**M4 (JUNCTIONS 3 TO 12) (SMART MOTORWAY) DEVELOPMENT CONSENT ORDER
APPLICATION**

TR010019

Written Summary of Issue Specific Hearing Dealing With Matters Relating to Other Matters

Date: Thursday 11 February 2016

Drawing title  
SIDE ROAD PLAN & PROFILE  
REGULATION 4(2) (e)  
SHEET 13 OF 13  
OLD SLADE LANE

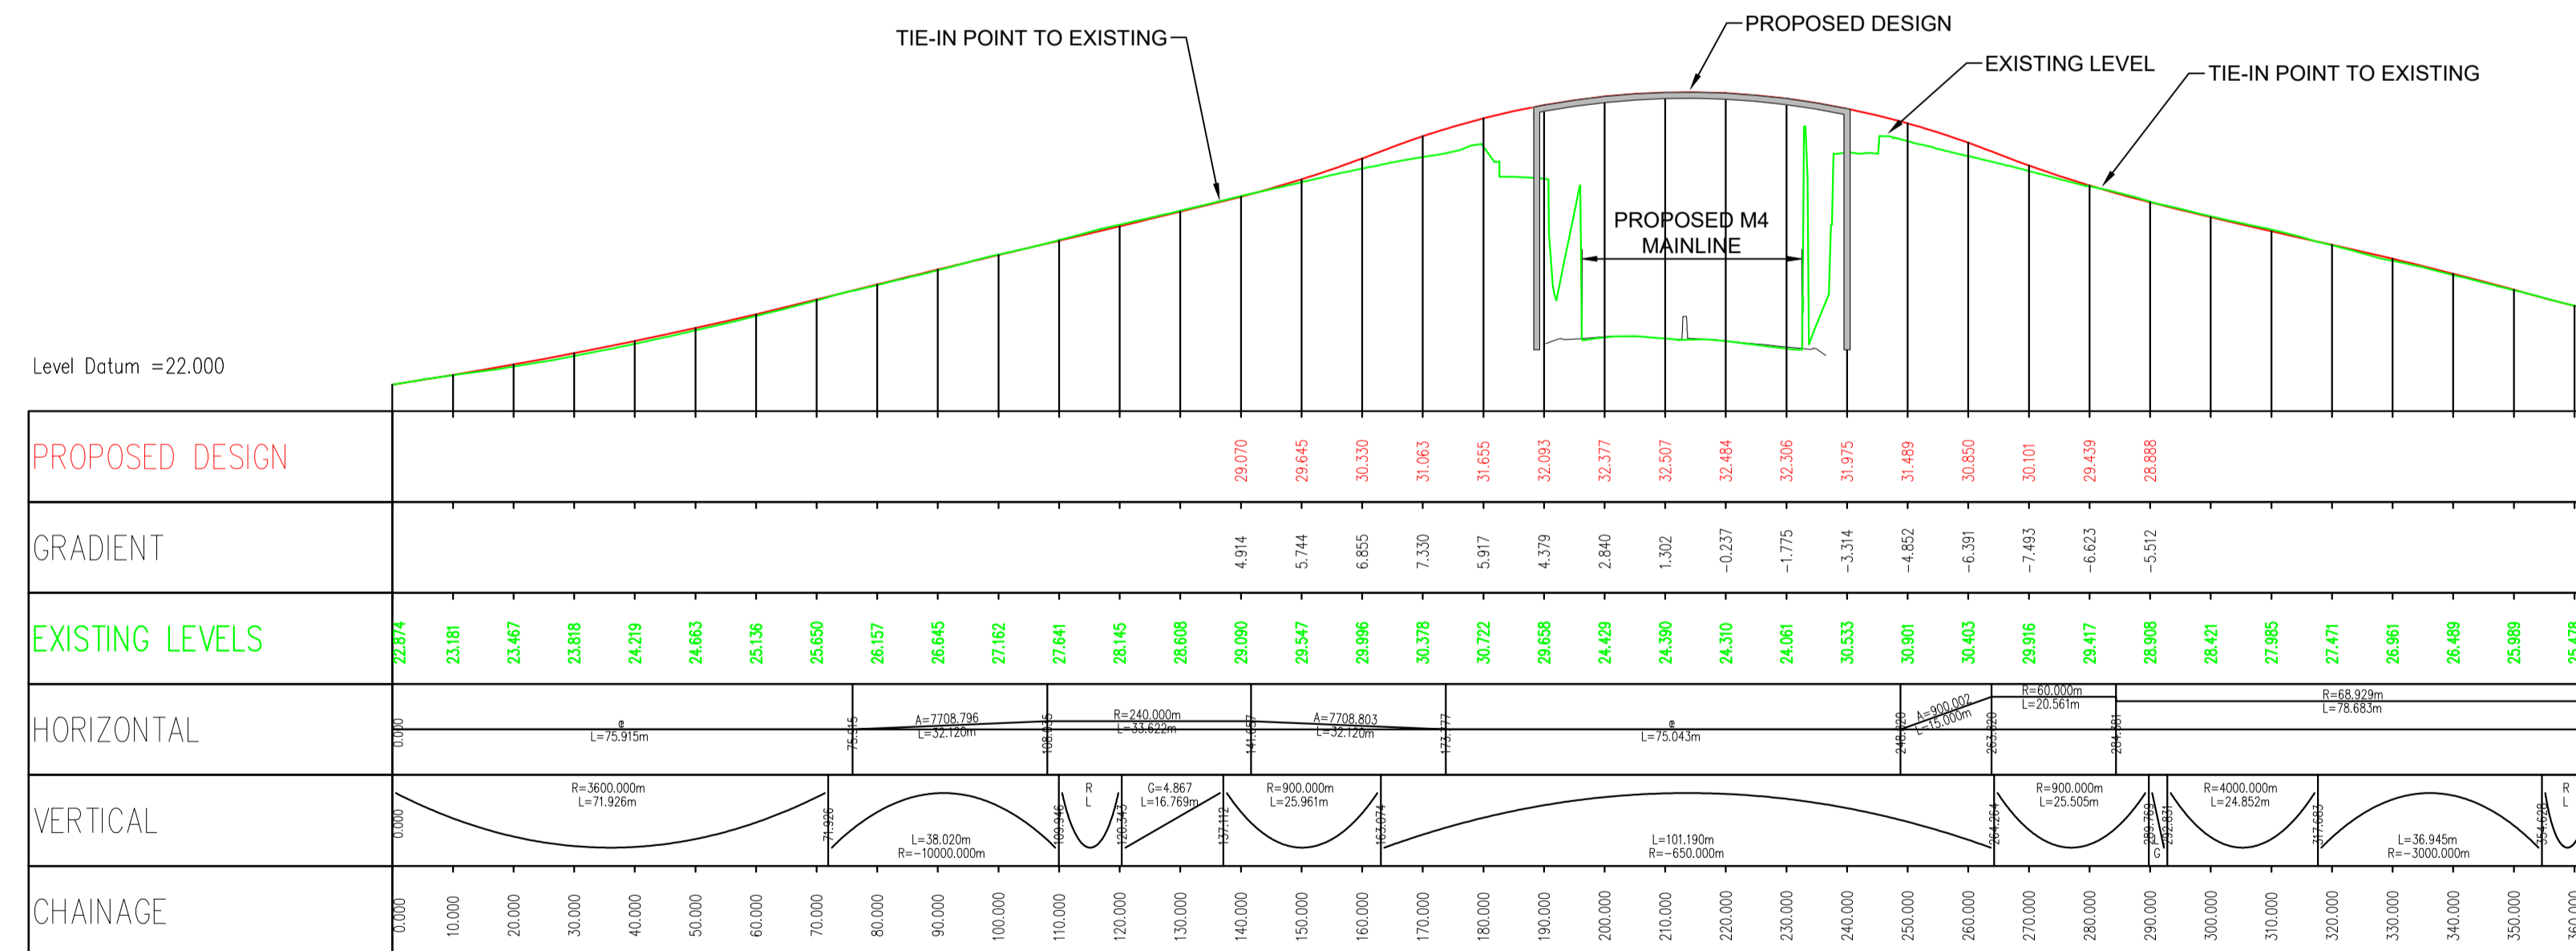
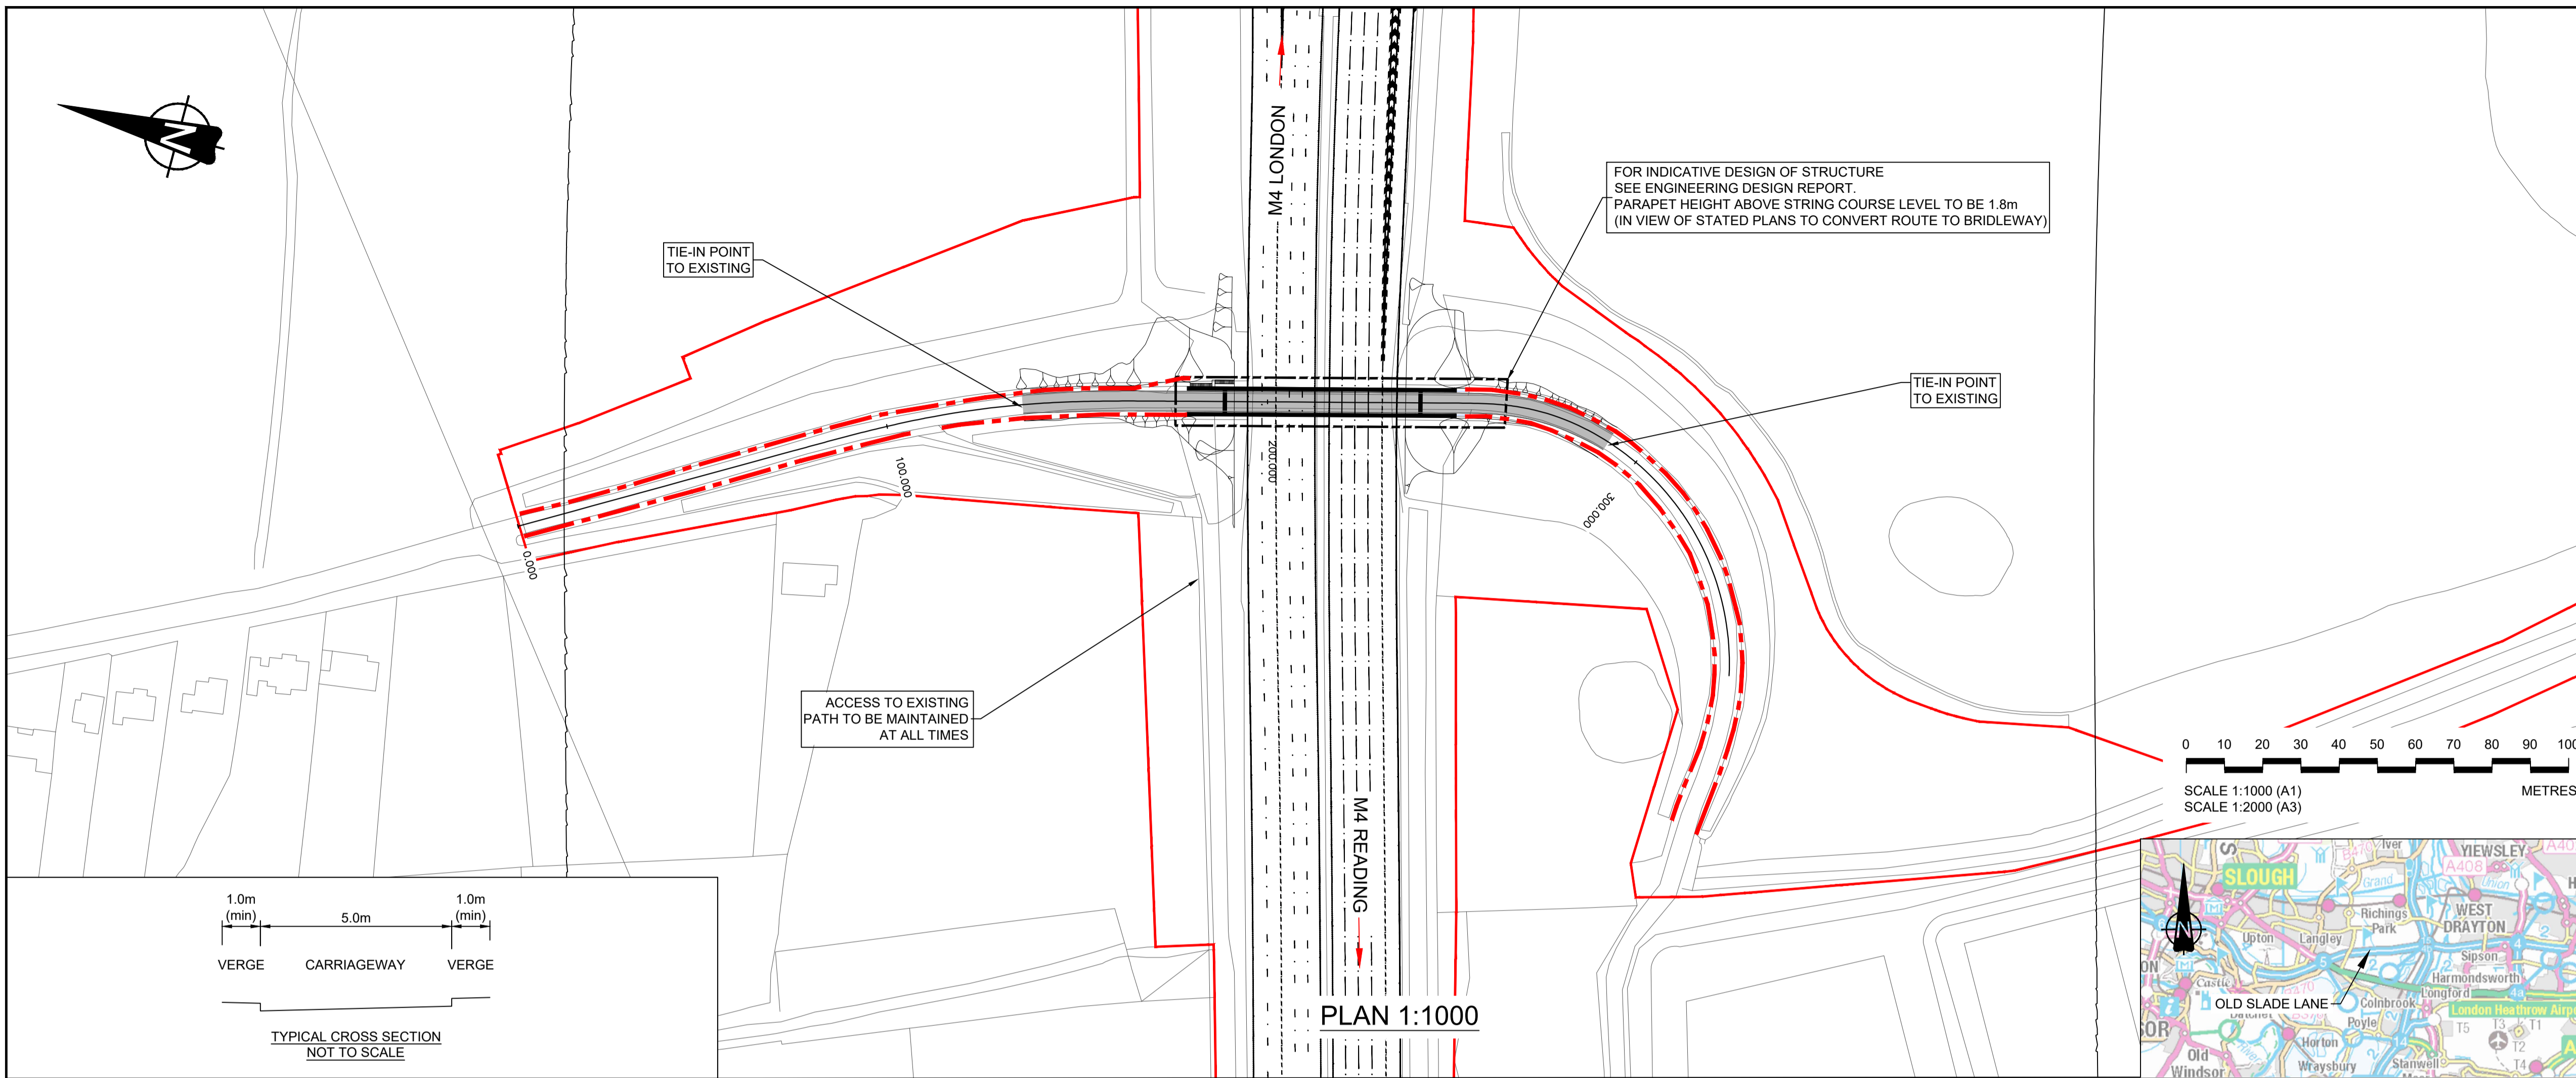
5. *Has progress been made in discussions between the applicant and BCC in respect of Old Slade Lane mitigation?*

5.1. Highways England confirmed that a detailed written response to the submission from Buckinghamshire County Council at Deadline V (REP5-009) regarding Old Slade Lane was provided by Highways England at Deadline VI (REP6-19). Given the low levels of current usage and the availability of alternatives, Highways England does not consider that any further mitigation in addition to that detailed in the ES is considered proportionate or appropriate. In the response, Highways England also raised concerns as to the suitability of the suggested mitigation works and noted that the further mitigation proposed by Buckinghamshire County Council was located outside the Order limits of the Scheme.

5.2. It was noted that Highways England and Buckinghamshire County Council discussed the matter further on 05 February and 08 February 2016 and further potential mitigation was discussed, including the funding of alternate route upgrades and reductions in the period of closure.

5.3. The outcome of these discussions is that Highways England does not consider that funding of upgrades to alternate routes is proportionate or appropriate. However, Highways England's contractor is investigating the feasibility of reducing the period of closure of Old Slade Lane from the 12 months that is detailed in paragraph 13.7.21 of Chapter 13 of the ES (Application Document Reference 6.1, APP-153).
